ETHOS URBAN

Response to Agency Submissions 2

Redevelopment of Greenwich Hospital

18 June 2020 | 2190376

PLAN OF DETAIL AND LEVEL OVER LOTS 3 & 4

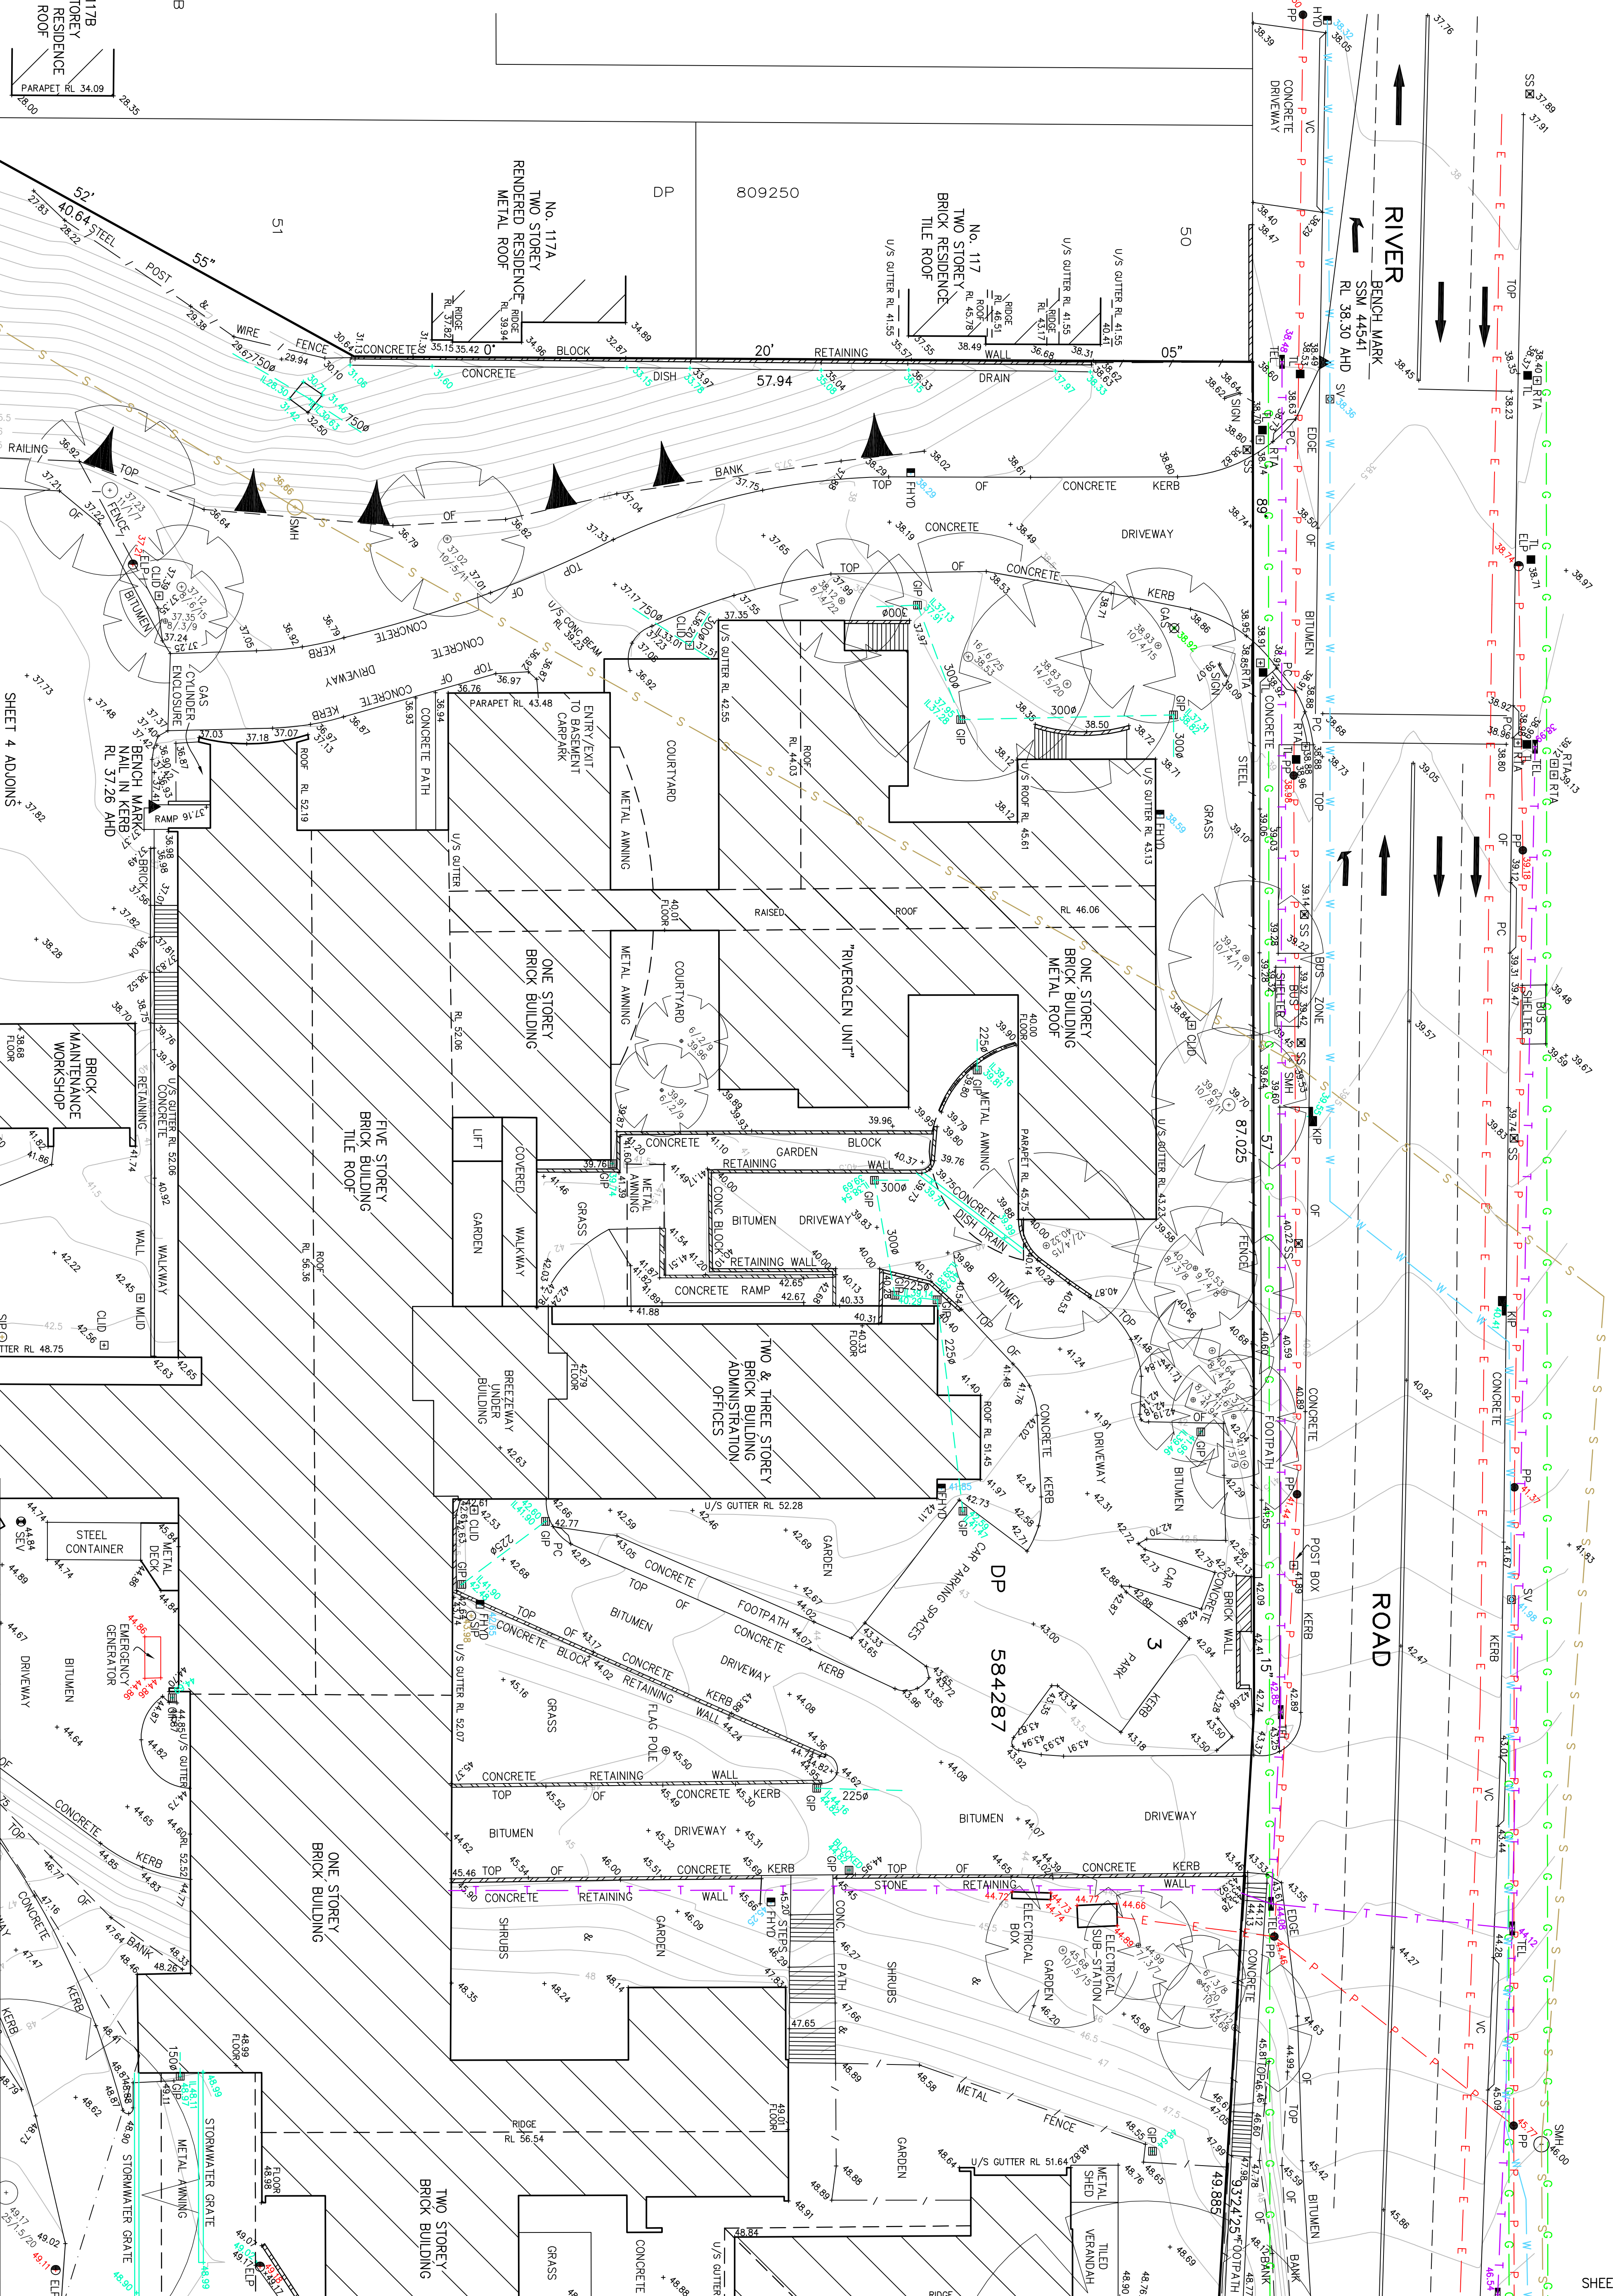
Issue	Response
<ul style="list-style-type: none"> The contours are incorrect on the south west corner resulting in the shadow analysis being incorrect. The contours are steeper than the survey conducted, which is reflected in the Civil Engineering documentation. 	<p>The southwestern extremity of the site was not surveyed in the original Site Survey (Appendix E of the original EIS) and the contours were estimated by interpolation. This was due to the excessively steep terrain of the area which inhibited access and was clearly identified on the Survey Plan. There is no development proposed at this part of the site and the shadow diagrams and other supporting studies remain accurate for the purposes of the proposed building envelopes. Notwithstanding, it is noted that the application seeks Concept Plan approval only, and that further assessment will be carried out as part of the detailed design application. If any supporting studies rely on an accurate survey of this part of the site, this will be identified and addressed at this time.</p>
